Application Ref: 24/00010/DPP Pre-application Ref: _____ Online App

<p>UPRN: 000120025416 (If NO UPRN – Admin to contact Technician)</p> <p>Site Address: <i>(Leave blank if no UPRN)</i> 6 CORONATION PLACE MAYFIELD DALKEITH EH22 5AE</p>	<p>Description of Proposal: Part change of use of garden to dog grooming salon and associated erection of outbuilding</p>
---	--

LOCATION PLAN & CO-ORDINATES

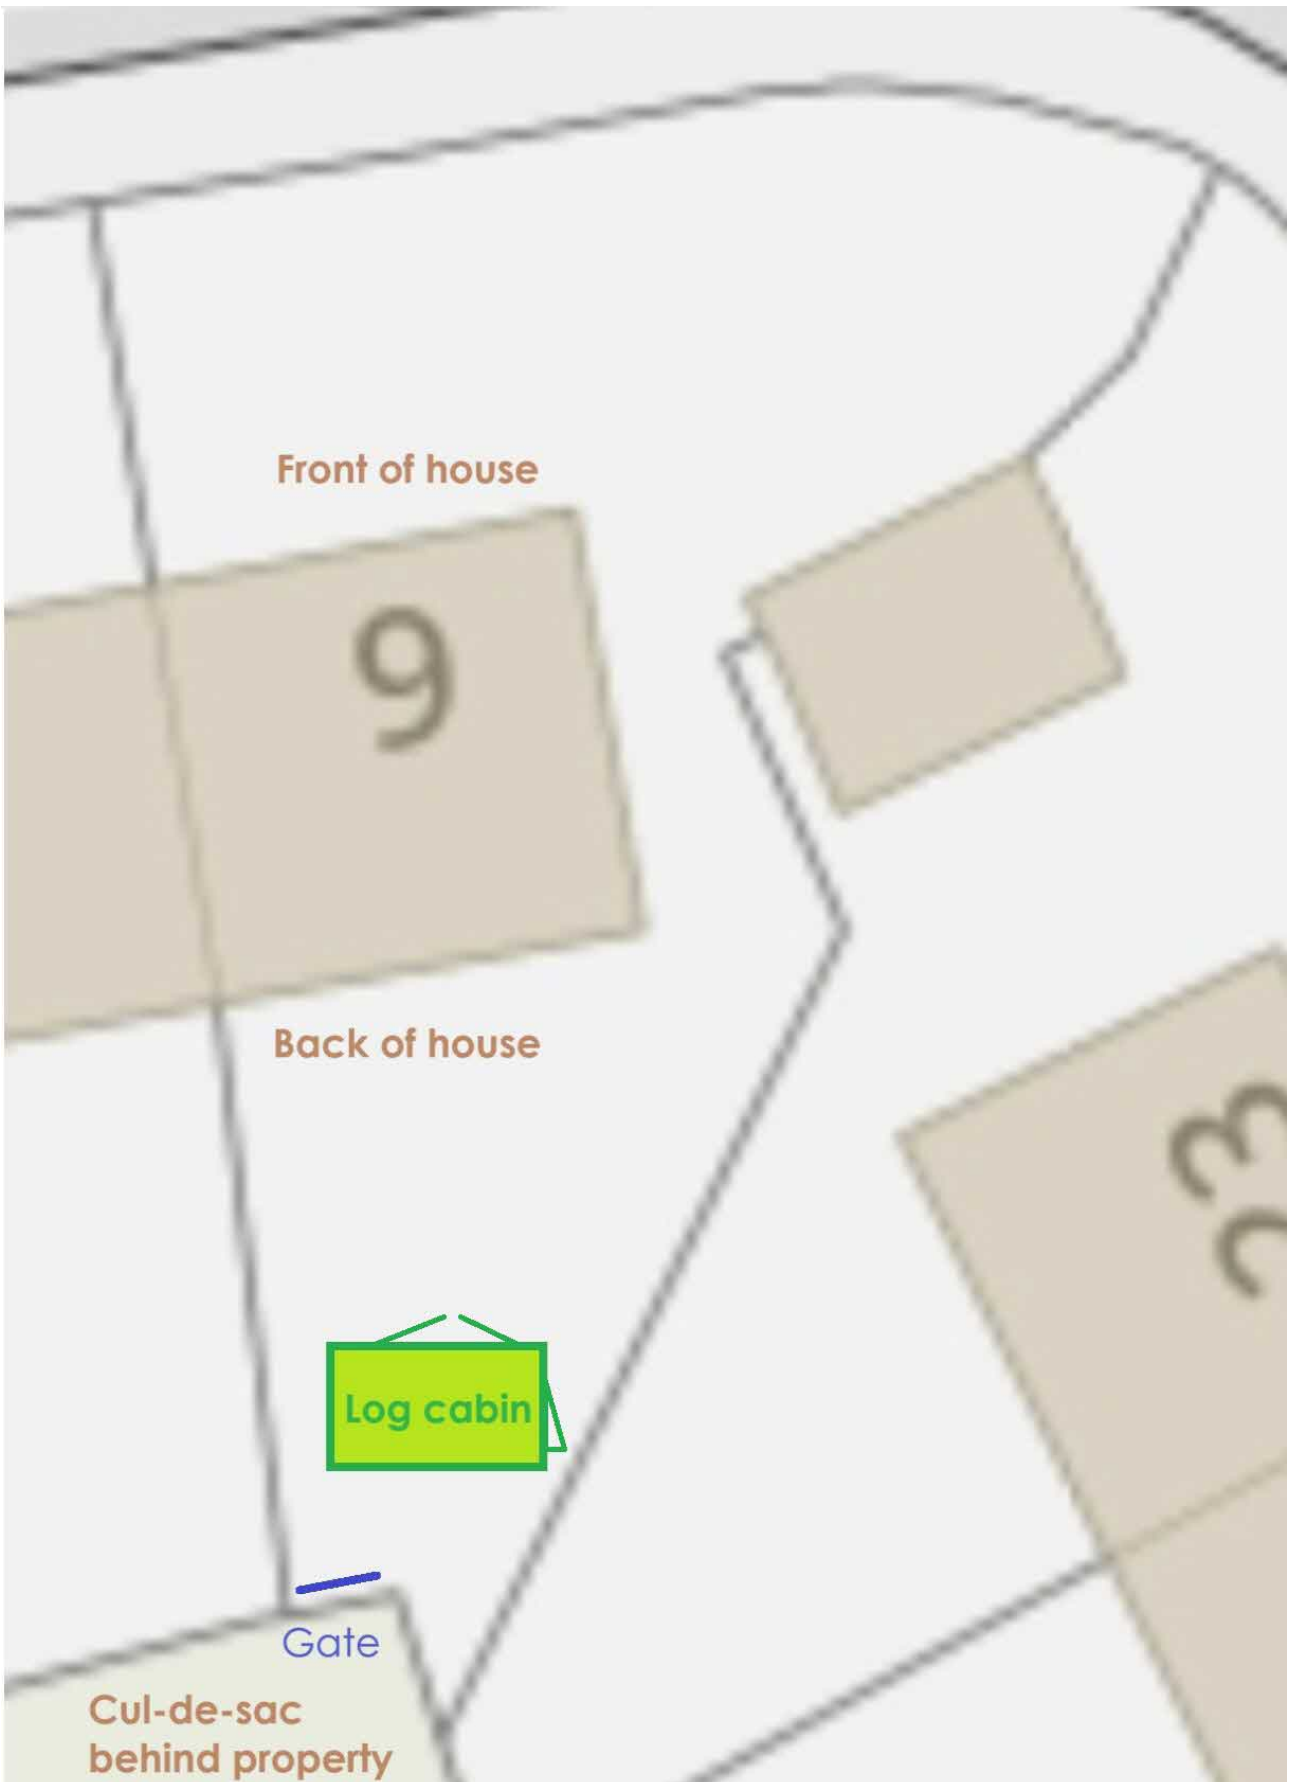
| <input checked="" type="checkbox"/> | Inadequate Plans | The following additional plans are required: <ul style="list-style-type: none">- The location plan should edge the full property boundary within the red line - The copy of the Land Register of Scotland that edges the property boundary in red would be sufficient, however, as this does not scale can you please mark up on this drawing the site area.- Can you please also mark up the proposed site plan the distance between the proposed outbuilding and the neighbouring boundaries |
